**ADC Planning Consultation
Response from the Historic Buildings Adviser**

Application Number	A/165/14/PL
Address	Littleworth House, Angmering
Description	Conversion & extension of existing garage/barn to form 1 No 2 bedroom dwelling with garages. This application affects the character & appearance of the Angmering Conservation Area & affects the setting of a Listed Building.
Case Officer	Anita Gardner
Site Visit	18 March 2015

PROPOSED FLOOR PLAN

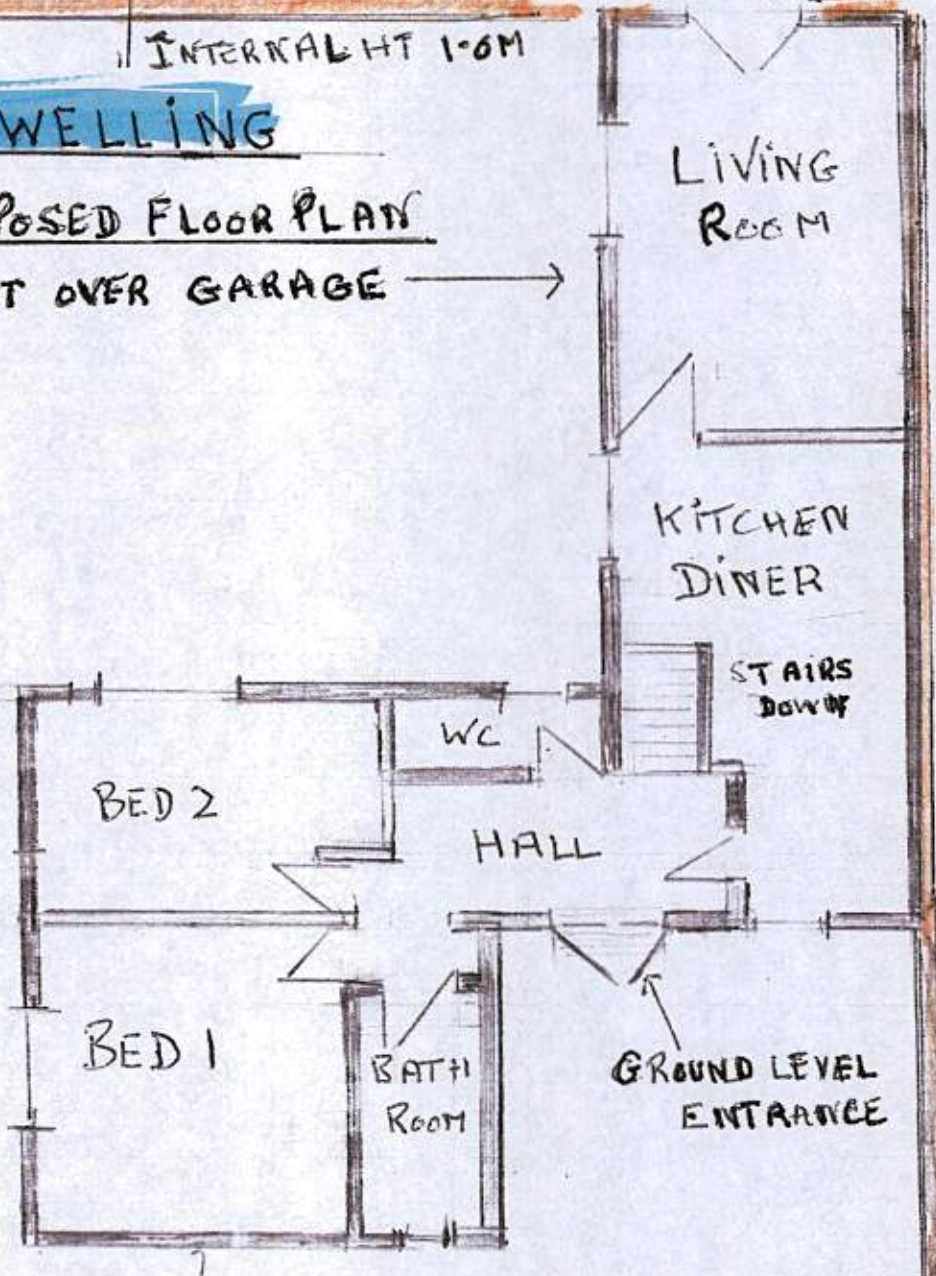
Within the grounds of Littleworth House, the experience of the listed building is also likely to be harmed by the presence of such a large and generic looking dwelling as well as the associated walling which divides the garden. The fact that this does not represent a public amenity is not relevant and thus carries similar weight.

NORTH ELEVATIONS

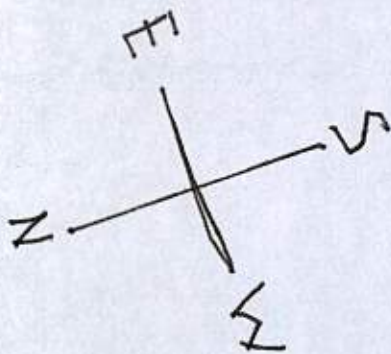
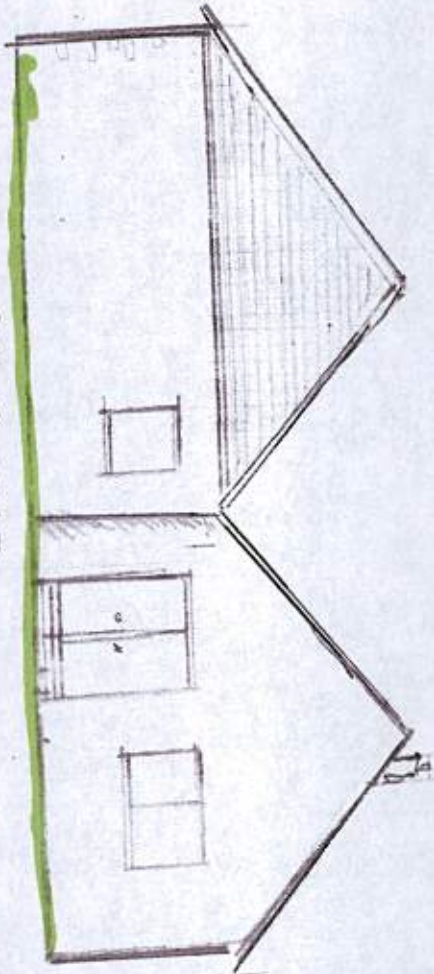
The existing barn (garage) is typical of the types of historic outbuilding in the area which address the street scene directly. Its modest form and scale are important to its typology as well as to its relationship with Littleworth House which is a simple end of terrace building. The addition of a large domestic extension and features such as first floor double doors and a dormer window breaking the eaves would harm this dialogue and be highly inappropriate.

Within the Conservation Area more generally, development must seek to conserve and enhance and where this is not demonstrated, schemes should be resisted. In this instance, the scale, massing and design of the extension facing onto the street scape is not sympathetic with the historic grain and its character, or the group value of the historic buildings which inform this part of the area.

GARAGE ELEVATION FROM SOUTH

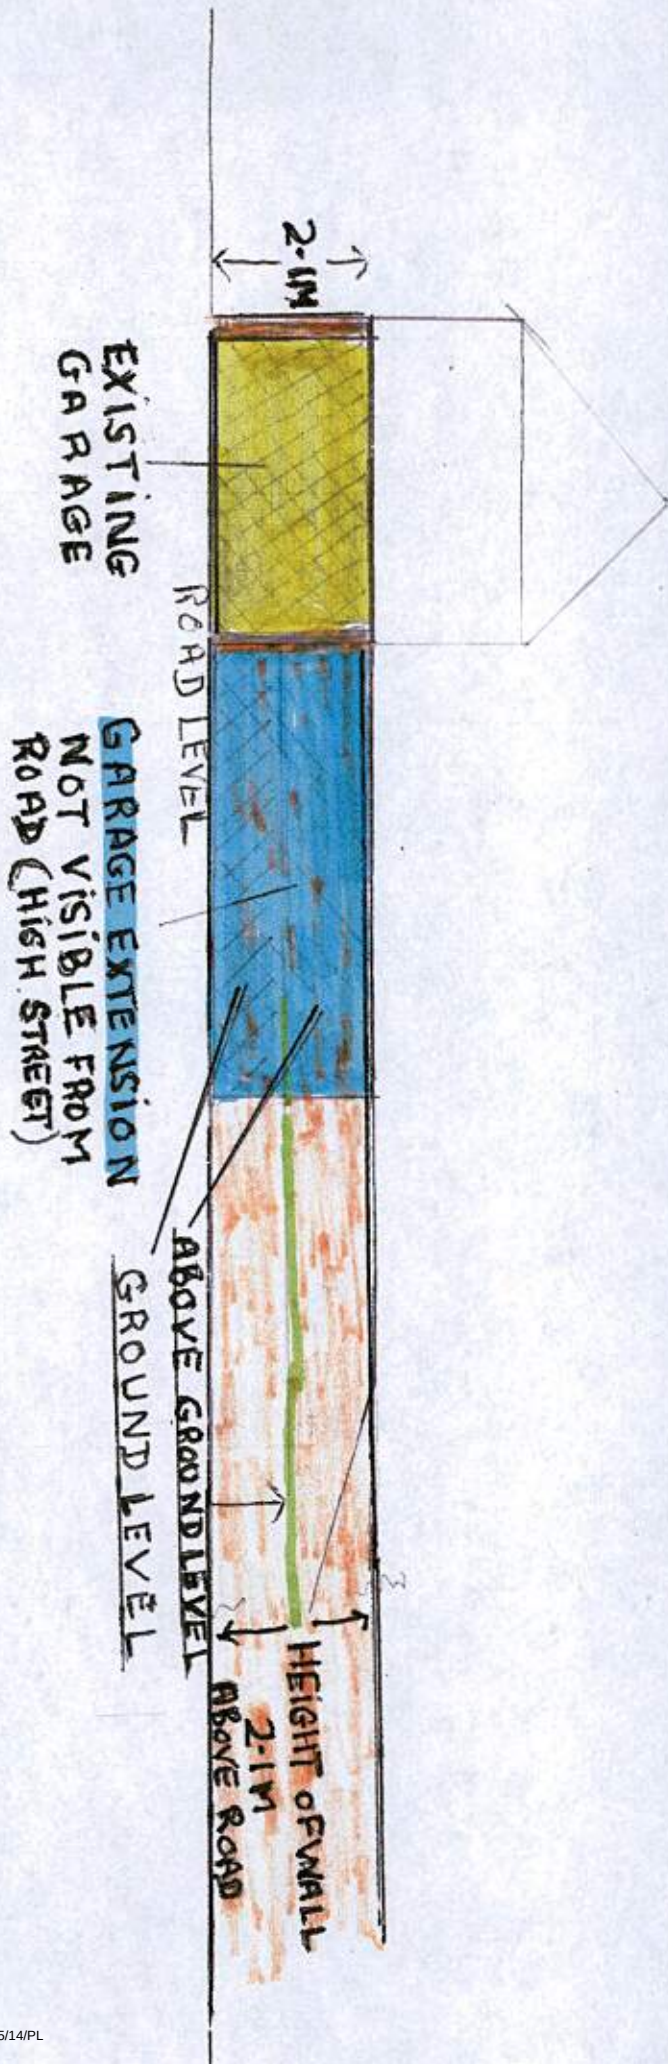
This development, along with a large flat roof garage is also likely to have a harmful impact on the setting of the neighbouring listed buildings. The experience of Littleworth House, Littleworth Cottage and The Spotted Cow are all likely to be affected by the scale and massing of the new building as approached from the west, whilst from the east, the approach into the Conservation Area is also likely to be harmed. Such impacts need to be assessed in accordance with English Heritage guidance, *The Setting of Heritage Assets* (2011). These are not evident here.
